**ANNEX 3
COMPLIANCE OF ENVIRONMENTAL STATEMENT WITH EIA REGULATIONS**

05. NORTH ELEVATION

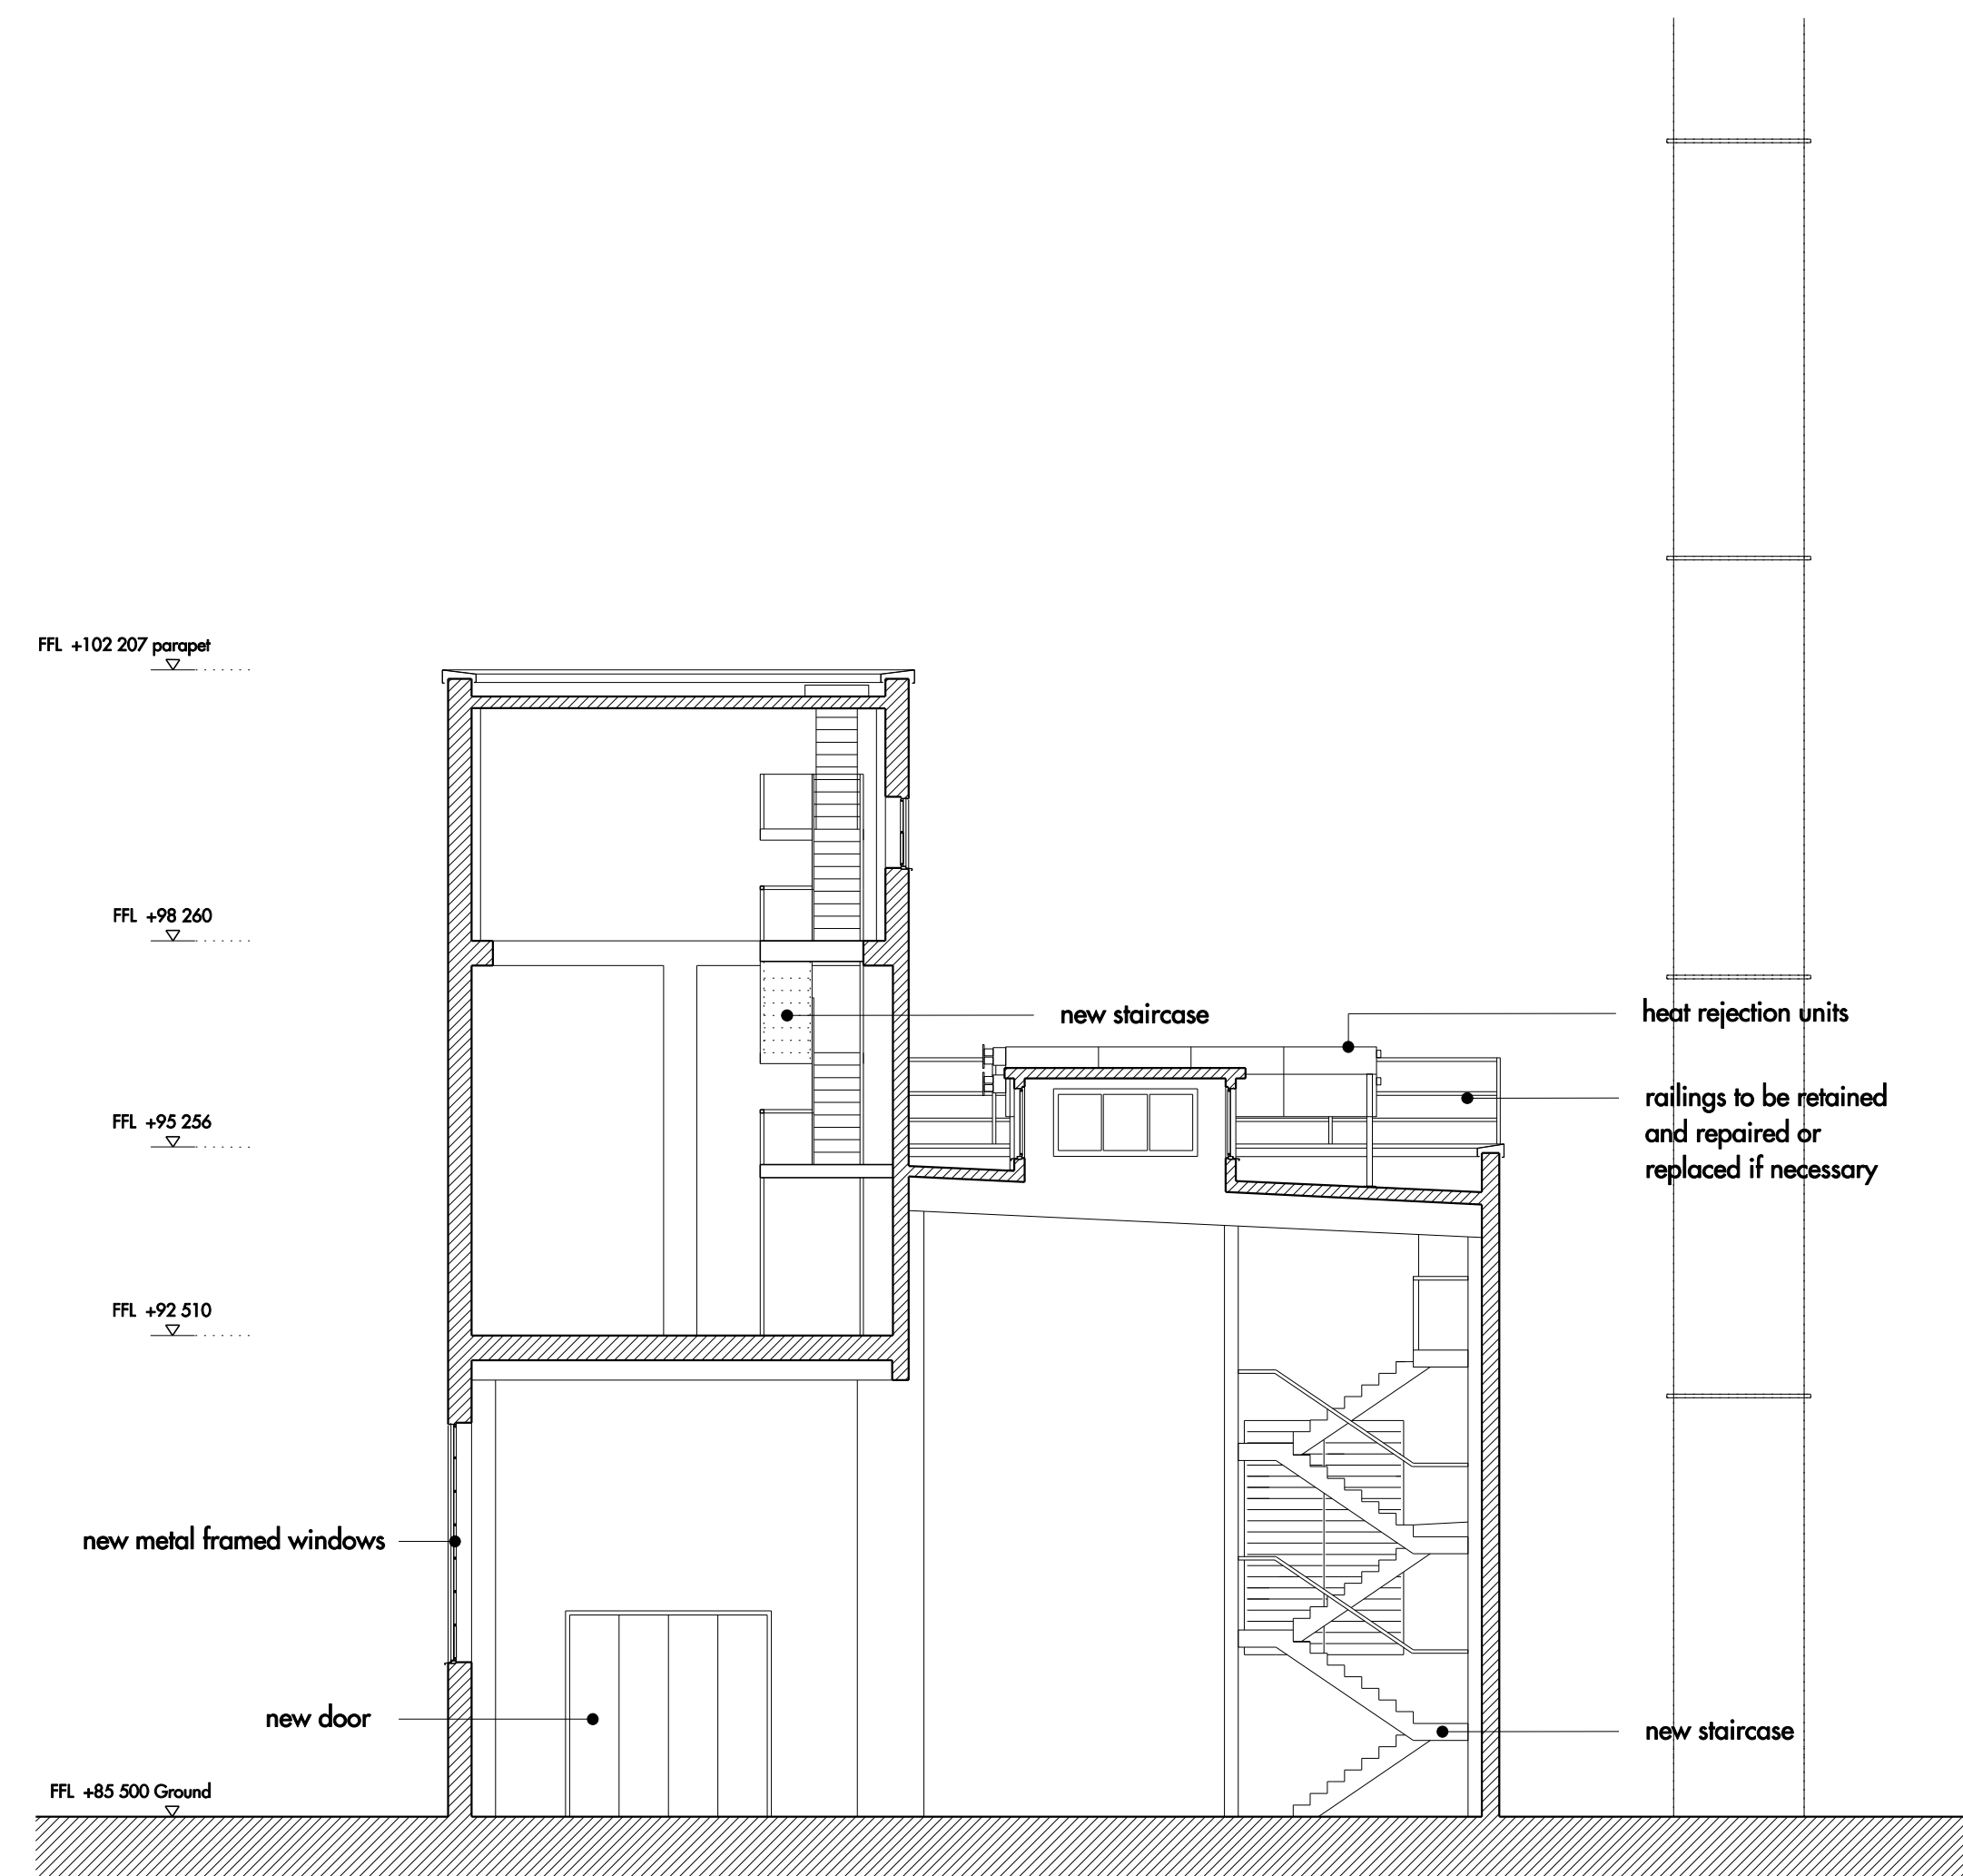
L,C,B,S Ref	ES Ref	Comments	Requirement under ES Regulations	Whether or not complies
		<p>Retained Tree 85 missing from proposals plans.</p> <p>Section 2.1.11 of Part B states that 3 CHP boilers + 3 gas boilers will be accommodated in the Energy Centre, but part C Volume 3 Appendix C seems less certain. Appendix C states that best practice will require individual flues for each of the three proposed CHP boilers, but there does not appear to be enough room for this (Appendix A). A planning condition requiring detailed proposals for flues to be submitted prior to commencement of construction would be appropriate.</p>		
<p>1.1.3 Indication of physical presence / appearance of the development</p>	<p>Section 2 of Part B of ES, and Section 2 of Volume 1 of Addendum. Plans and parameters plans in Part D of ES and Volume 3 of Addendum</p>	<p>Plans are generally clear and easy to reference. Plans and elevations provided for the detailed application area. Parameters plans provided for the outline application area.</p> <p>EIA Part D – Good level of information on general elevations & sections, with further information provided by detailed elevations More information provided by descriptions in Part B Section 2, with additional information in Vol 2 of the Addendum and by the photomontage views and descriptions (Section 5) in Part C Vol 3 Appendix B12 and in the Addendum to the Townscape and Visual Assessment</p>	<p>Not a requirement under the Regulations</p>	<p>B</p>
